## **SUBMISSION FOR APPLICATION No. SSD5752**

Please find the submission below that OBJECTS to the current Development Application SSD5752.

We are owners in the Goldsbrough, a residential building of approximately 500 apartments, which is located directly behind the proposed ICC Convention Centre.

**DRAWING TITLE**  
WEST ELEVATION

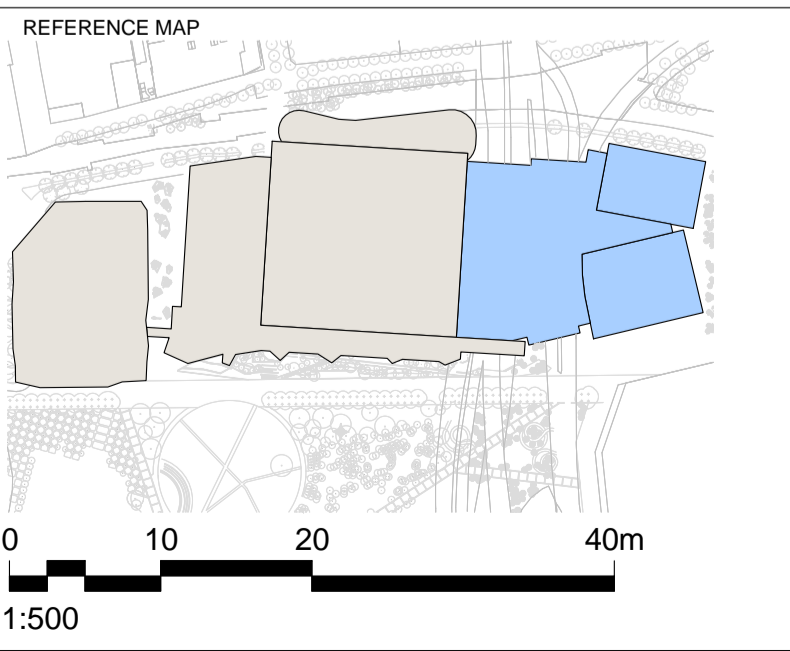
- **OBJECTION 4: NO CONSIDERATION FOR AESTHETICS ON THE WESTERN OR REAR FAÇADE OF THE ICC.**

As mentioned in objection 1 once the ICC is erected, the view of the city skyline and Darling Harbour will be replaced by a mainly Grey metal panel wall, which will look like a Grey metal barricade from the Goldsbrough. All the appealing glass frontage is kept for the Eastern face of the building. Any photographic shots show the view of the East face yet all the Goldsbrough will see is the ugly grey panel wall. If this is the case then at least some regard should be paid to the fact and the Western face of the ICC modified to be more aesthetically appealing.
